CUMBERLAND
CITY COUNCIL

Ref: OA2020/0013

Subject: Request for comments-State Significant Development (SSD)
Application No: SSD-10407
Property: 14 & 16 Kiara Crescent YENNORA NSW 2161
Proposal: Ministerial Consent - Expansion of existing liquid waste treatment facility for increasing processing and storage quantities and hours of operations to 24/7

1 Swept Path 1
1 : 200

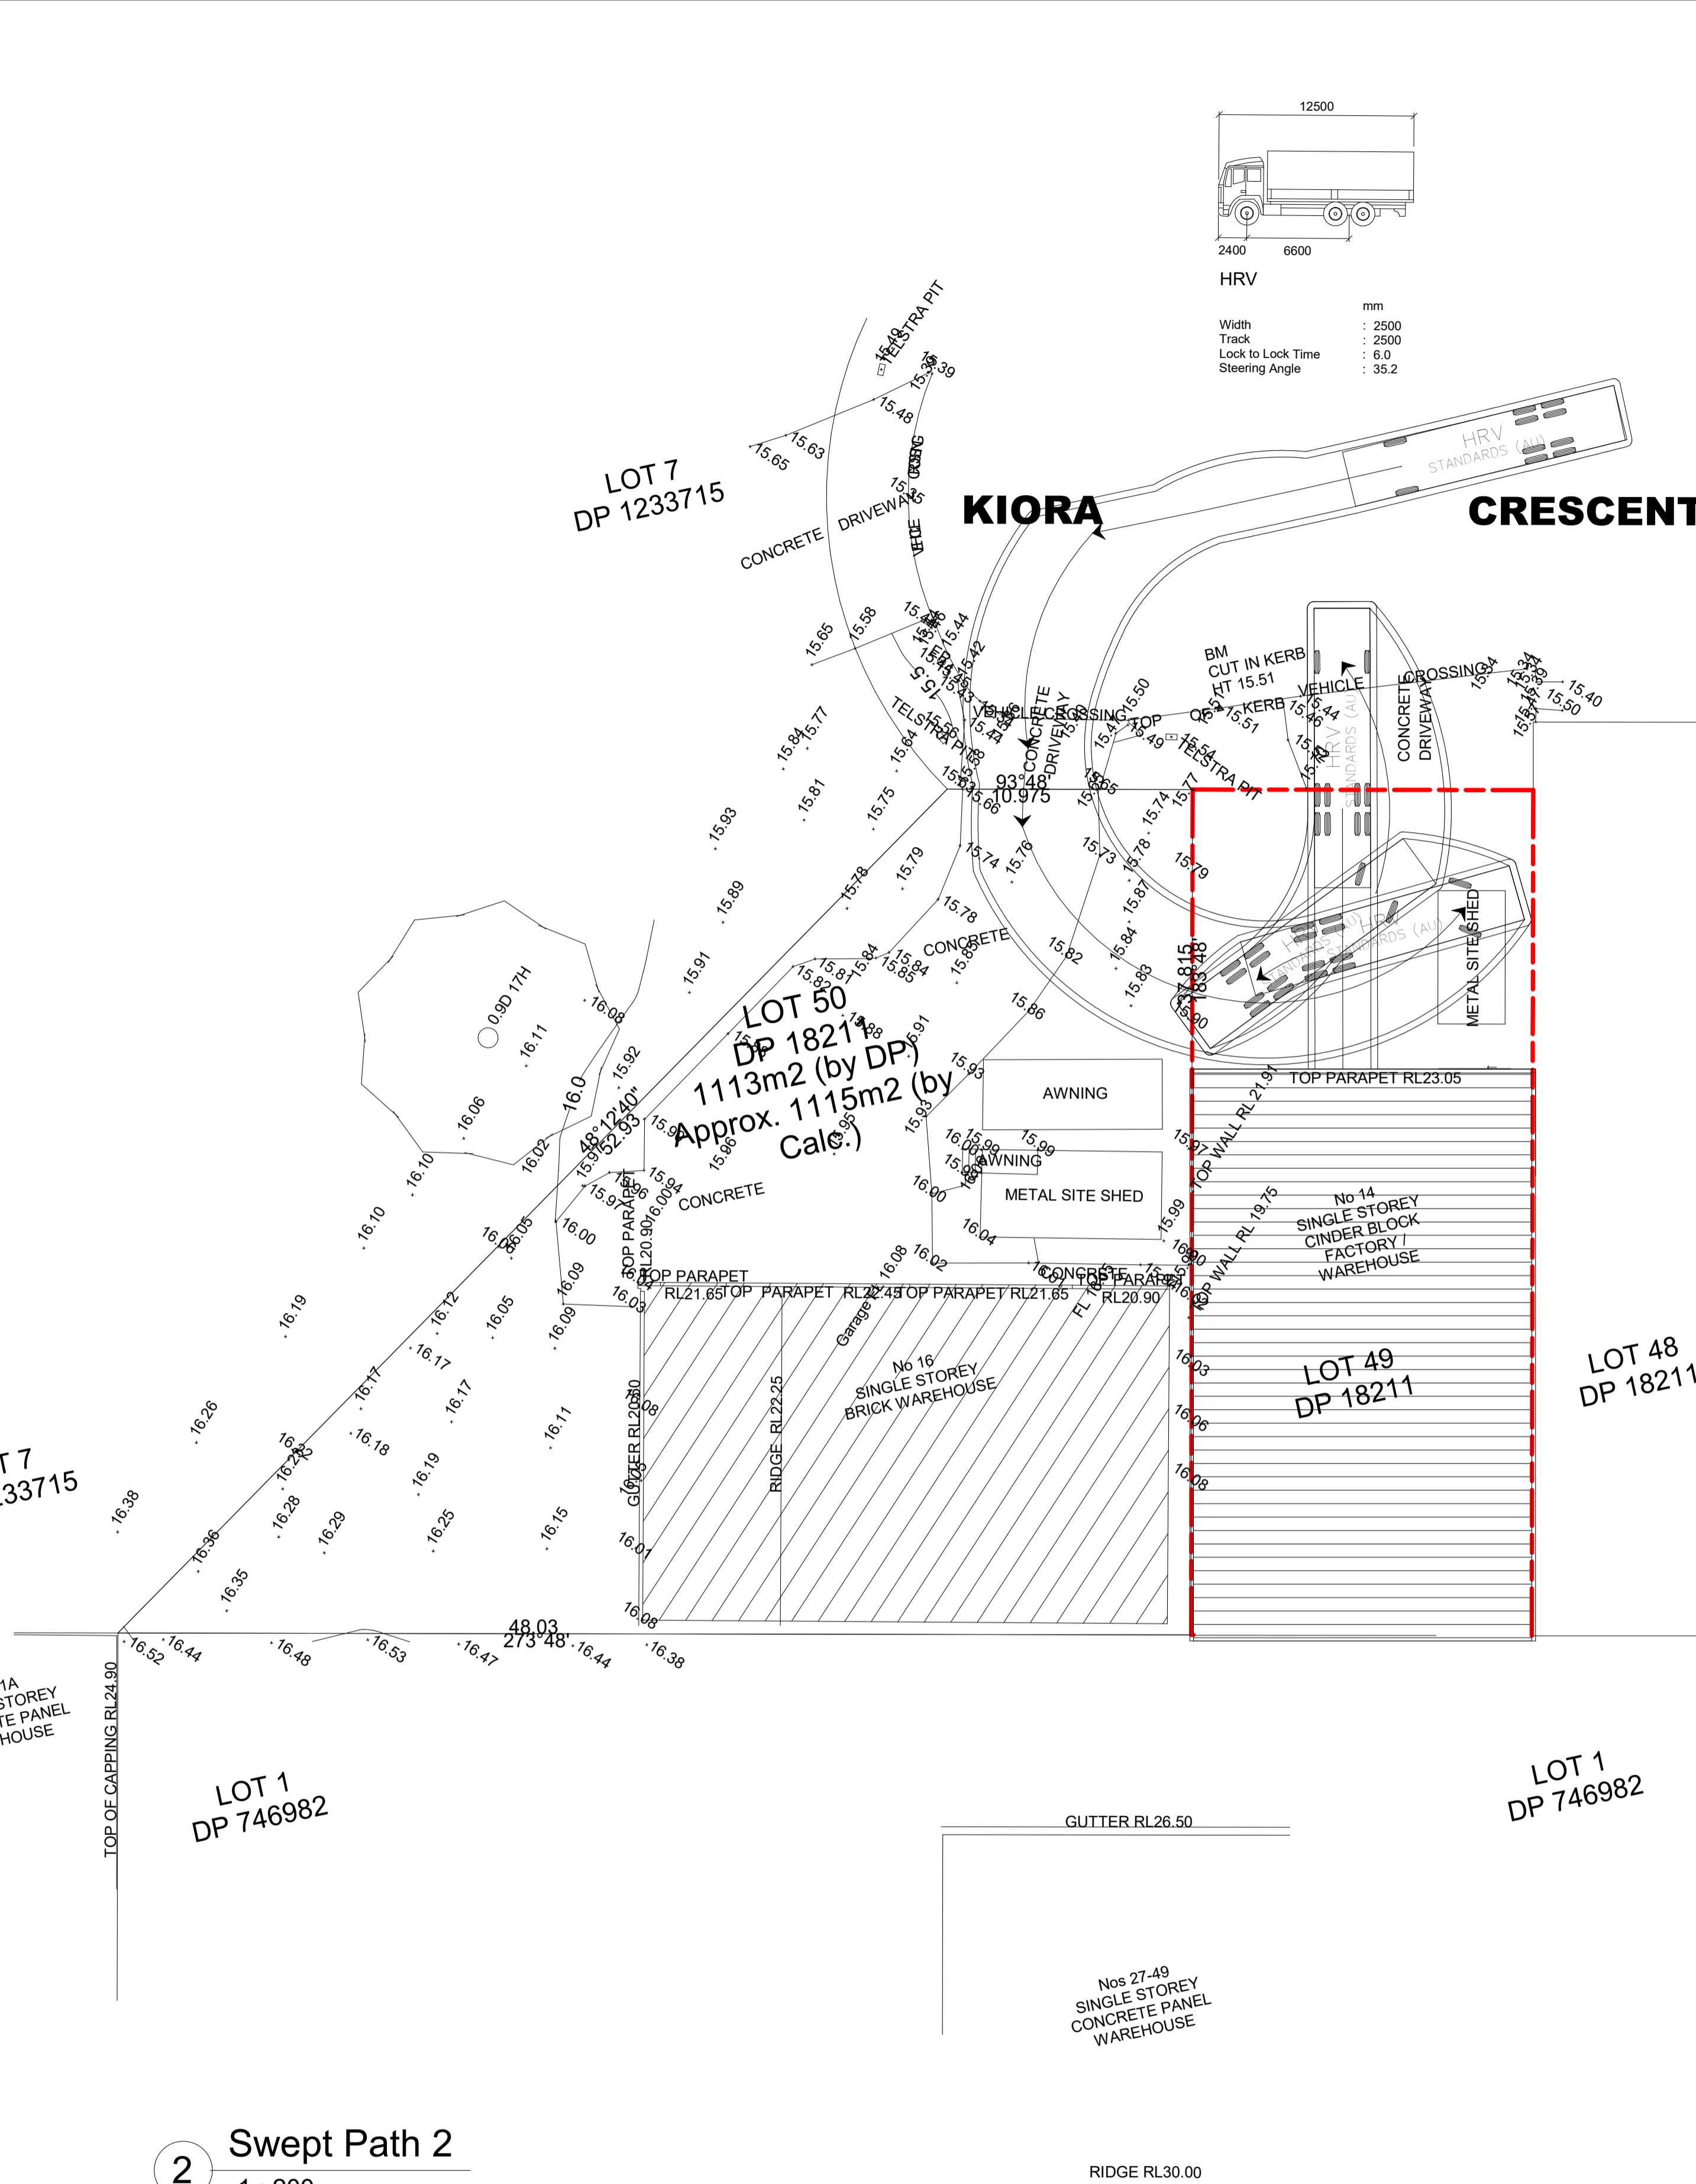
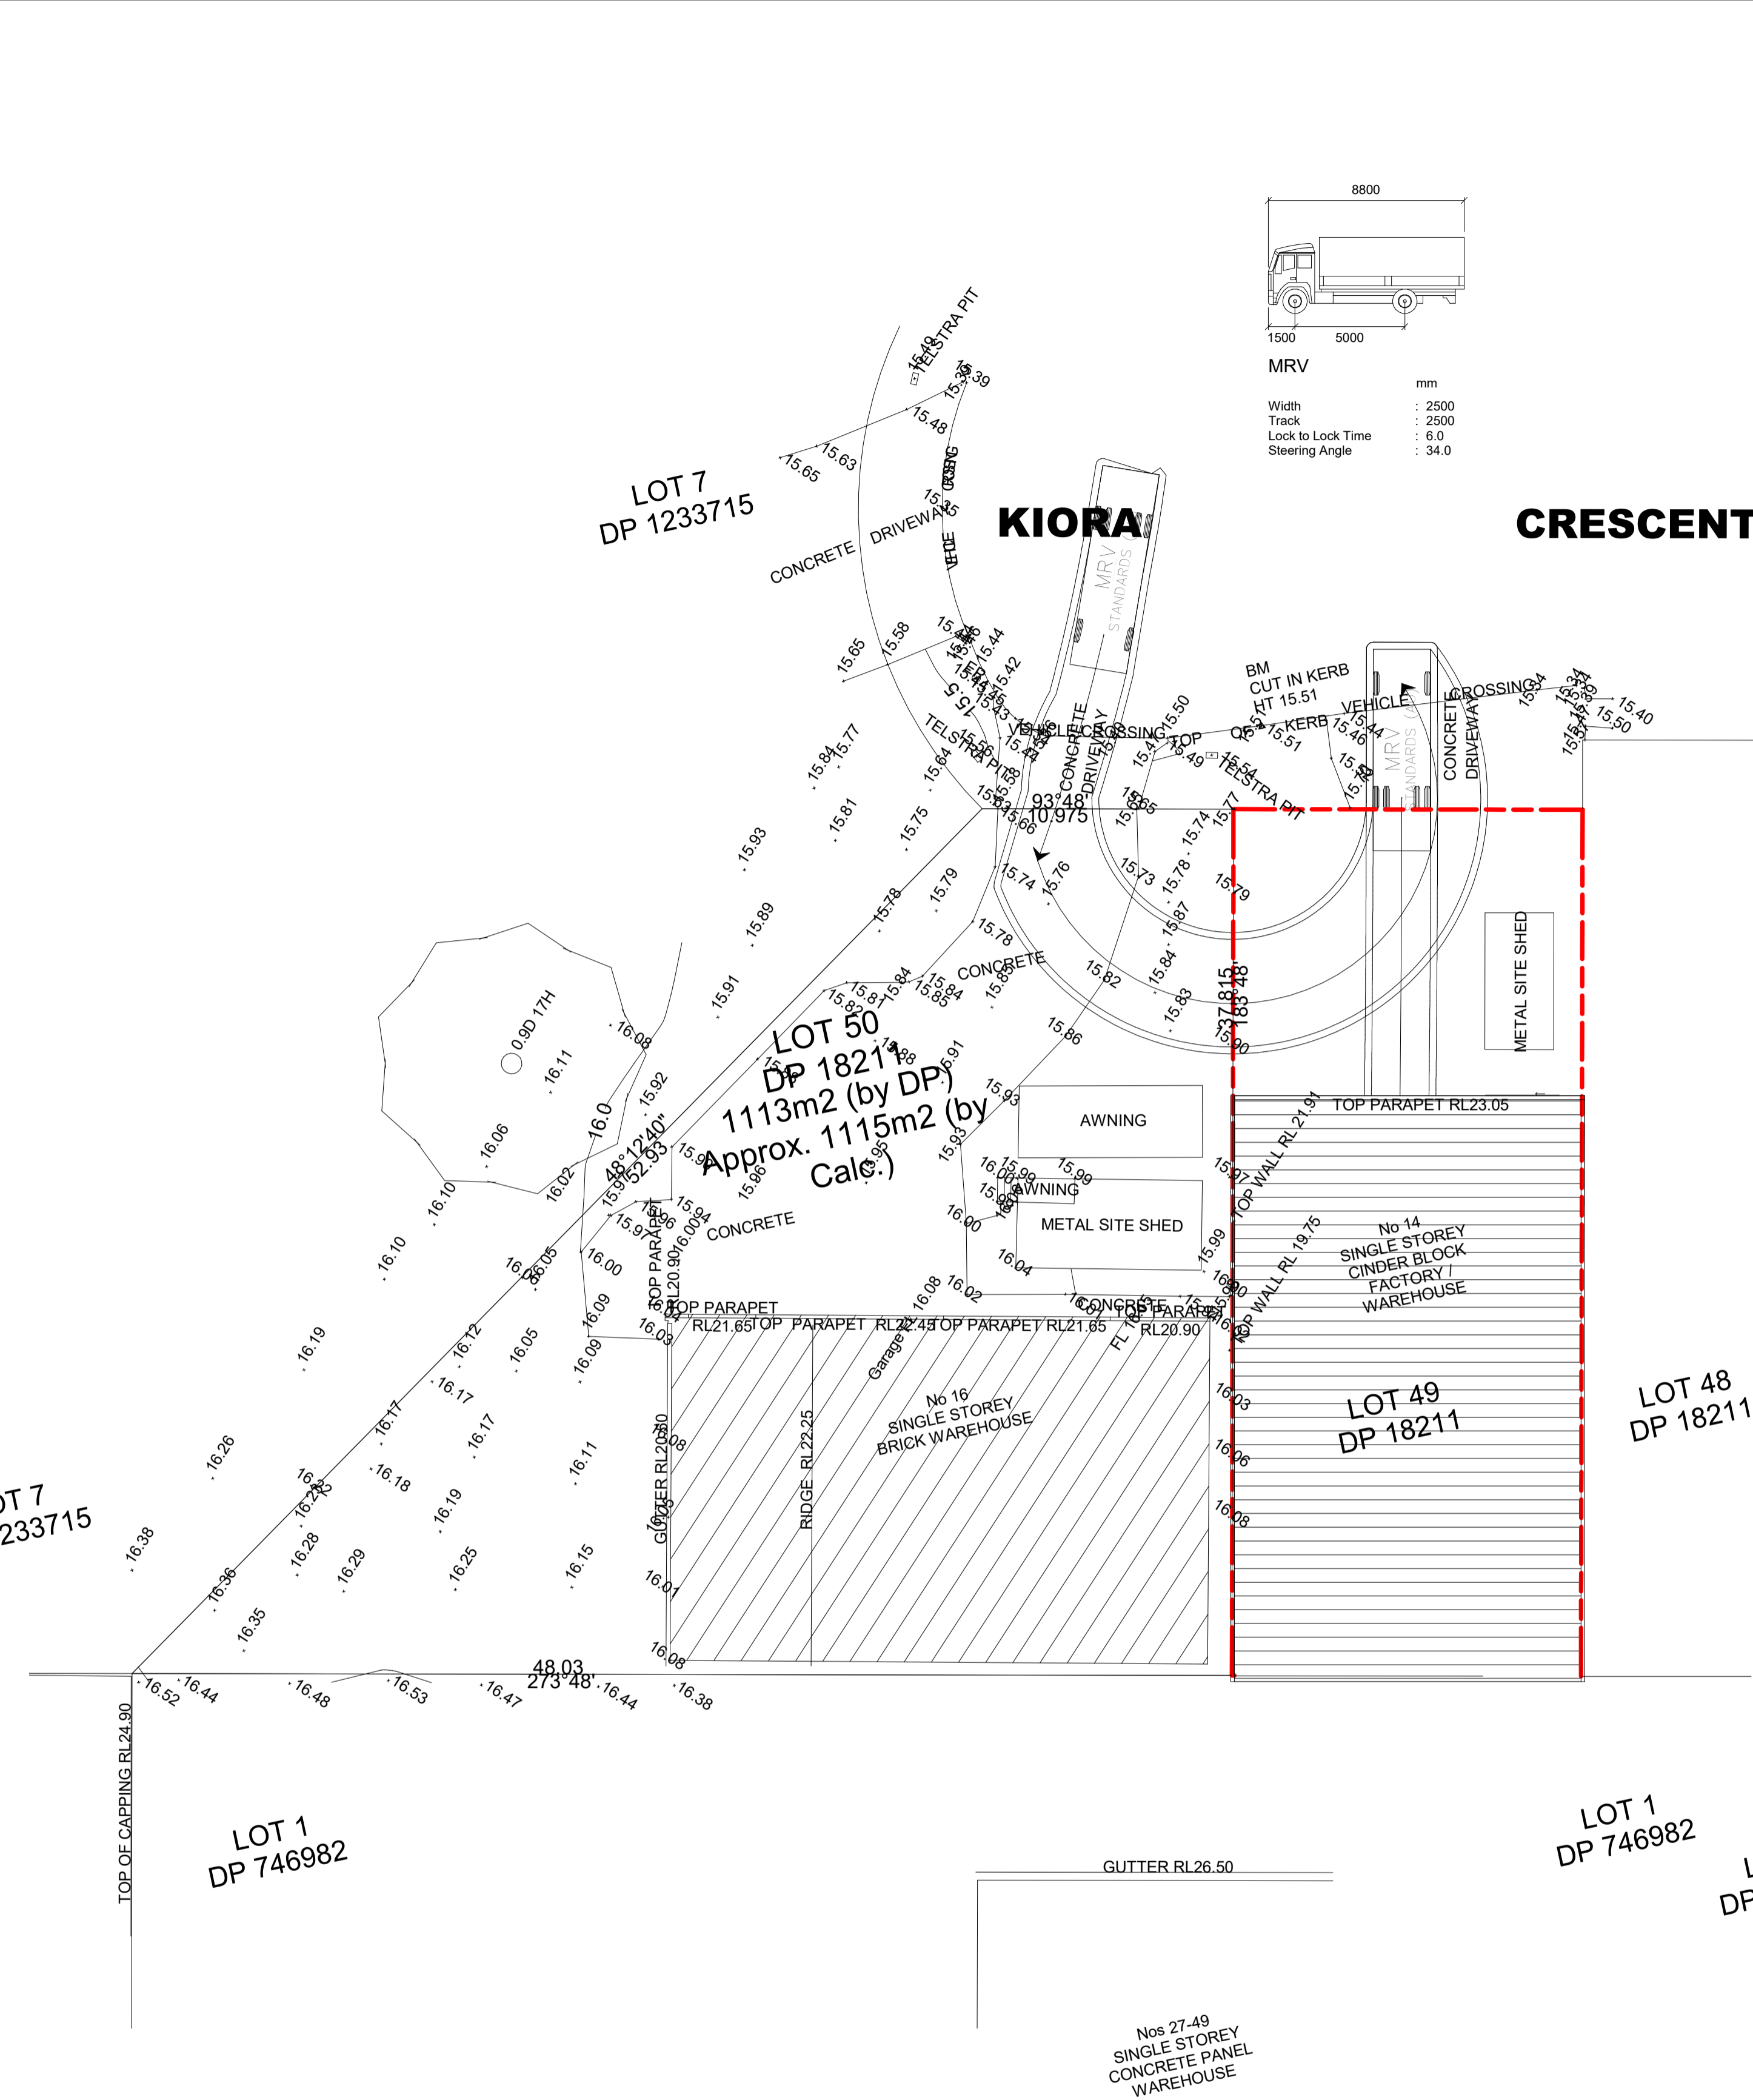
- a) The 10.0m truck used in the swept path analysis is not a standard truck that is defined in Australian standard AS2890.1. Further, the swept path clearance turning with 12,5 standard turning circle must be used.

- b) The manoeuvring and turning of the vehicle must be completed within the site and must not cause encroachment into nature strip or the footpath. The swept path diagrams demonstrate otherwise with the encroachment into nature strip.

- c) Sufficient swept path diagrams must be provided to demonstrate that the turning and manoeuvring of the truck is possible for all, entry and exit for both processing plant. The swept path must demonstrate with a truck in the waiting/stand-by bay.

- d) Further, the Truck swept path diagram also indicates the runover into the structure (entrance door jamb) and the car space for 16 Kiora Place.
- e) Reverse manoeuvring in Council's land is not acceptable. It will compromise the safety. Vehicles should enter and leave the site in a forward direction.

- f) Multiple point turn (more than 3 points) will result in additional time for the turning and manoeuvring thus overlapping with the arrival of another vehicle (truck) and causing obstruction and delay. Enough space must be provided for manoeuvring and turning with the minimum delay. The proposed 4-point turn truck manoeuvring movement is not acceptable. Manoeuvring shall be limited to three-point turn.

- g) Parking and loading design must comply with Australian standard AS2890.1 and AS2890.2. Further the design vehicle into consideration for the swept path analysis must be as per AS2890.2 (not UK standard as noted on the swept path diagram).
- h) The estimated peak hour traffic generation of the waste trucks is based on the assumption that the processing plant is operational 24 hours a day, 7 days a week. However, this is subject to the approval of the proposed operational management plan. Any variation to the operational hours will result in the increase in the frequency of the truck traffic. In such case the following must be complied:
 - (i) The traffic impact report must be revised and demonstrate how this will not result in adverse impact.
 - (ii) Additional facility/ area for holding the waste
 - (iii) Additional facility/area for the trucks waiting for unloading the waste.
